Property Address: 6925 Wyoming Lane, Colorado Springs, CO 80923

Planning Comments:

Add "PCD File No. AL2613" and document title "Rural Home Occupation Special Use Site Plan"

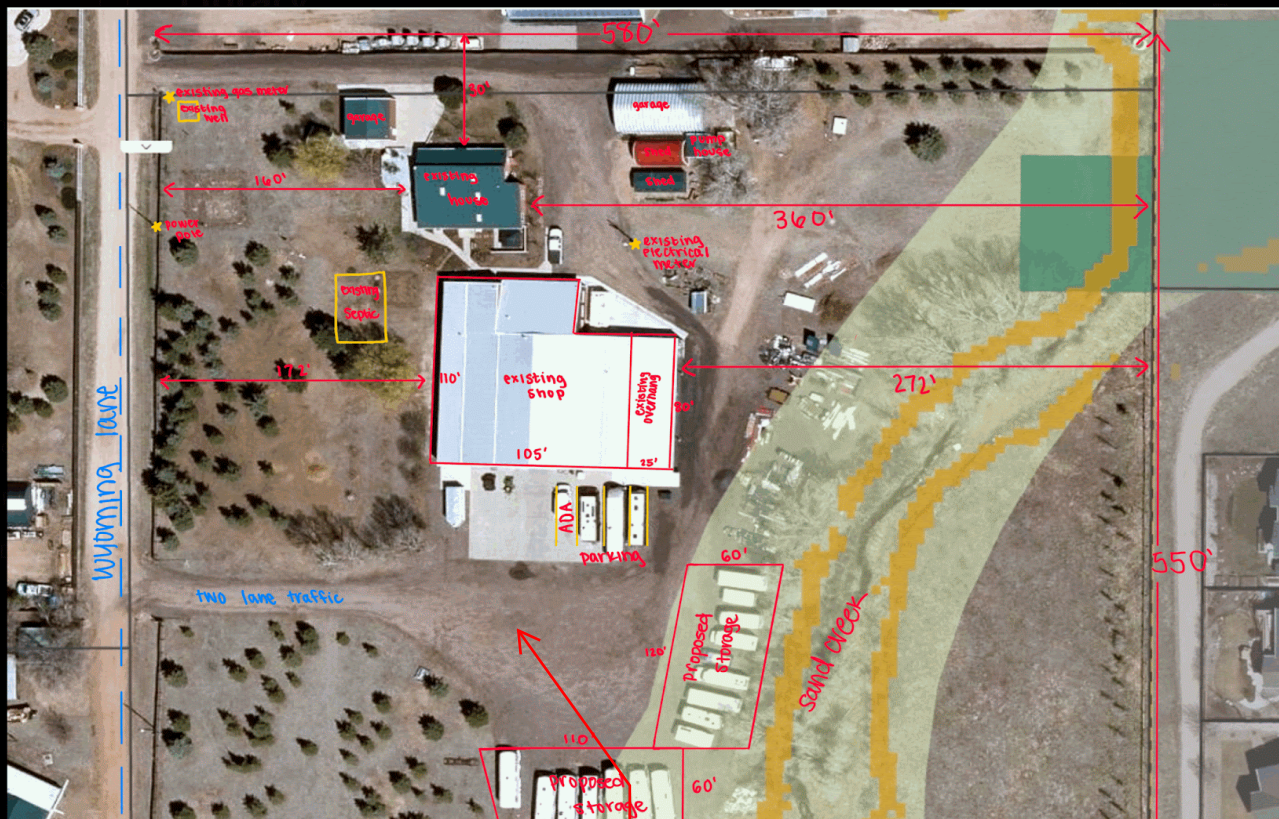
existing?

Structures appear to be within setback.

Identify.

Label floodplain drainage easement area. (add dashed lines for boundary area)

proposed RV maintenance parking area" as the RVs are not being stored as part of a RV storage business. Just temp parking for pending maintenance services.

<< If RV storage is part of the business, please clearly identify this in the Letter of Intent and on this Site Plan.

Are these proposed areas disturbing the land? (ie regrading, bringing in fill, paving, etc). Or are these boxes denoting the proposed storage areas but no changes to the land are proposed? Based on the LOI I'm assuming no changes or disturbance but please clarify on this plan

Identify all property lines (location and dimension). Your measurement of 580' does not appear to be a property line.

Providing a surveyed site plan is highly recommended due to the proximity of the accessory buildings to the northern property line. Please see "Exhibit A" in review comments.

After verifying property lines, identify distance measurements for all structures. At least two buildings appear to be within the northern side setback. **NOTE:** If the survey shows that structures are closer than 20' to the property line, a Dimensional Variance request before the Board of Adjustment will be required. A 20% encroachment can be permitted through Administrative Relief.

I could not find EDARP or PPRBD records for the accessory structures or existing shop expansion. If building permits were pulled, please let me know so that we can add these records to our system. All structures over 200 sq ft require building permits.

Proved a table showing all RR-5 dimensional standards. >>

There appears to be an additional access point north of the subject property (or on the north side of the subject property). Please address whether this is on your property or if there is an access easement/agreement in place with the adjacent property owner. If so, please include reception number of easement/agreement.

Identify all traffic circulation on the property. Provide width of all driving lanes.

Identify the location, height, and opacity of all fencing. Same for any walls.

All building dimensions must be identified. Include total sq ft and height.

The total cumulative area of outside storage needs to be identified.

Aerial image provided shows additional storage north of the identified RV storage. Please identify.

Add a note that clarifies that all depicted structures are existing and will remain (if that is the case). If some structures need to be removed or relocated to meet the zoning setback, please address as necessary.

Add labels to all buildings identifying whether they are used by the residence or business ("commercial").

All parking shall be clearly marked (ex: painted striping and ADA signage). Provide a detail of the parking dimensions, striping, signage, etc. Also, see note on Letter of Intent. Parking calculation will need to be provided in a table on the Site Plan.

Provide the distance measurement between all outside storage areas and the nearest property lines.

Label the landscaped areas. Provide a landscape table. 1. Roadway landscaping. 2. Parking lot landscaping, if applicable. 3. Landscape buffer between non-residential use and adjacent residential. 4. Internal (5%). 5. Other (refuse and outside storage). See EA notes from the planning checklist for the required minimum. The existing vegetation should meet the requirement, this just needs to be clearly labeled/listed on the site plan.

Add the 2 notes required by Colorado Springs Utilities (see EDARP comment).

Add the "FAA Form" note required by COS Airport Advisory Commission (see EDARP comment).

Identify the location of the dumpster/trash bins.
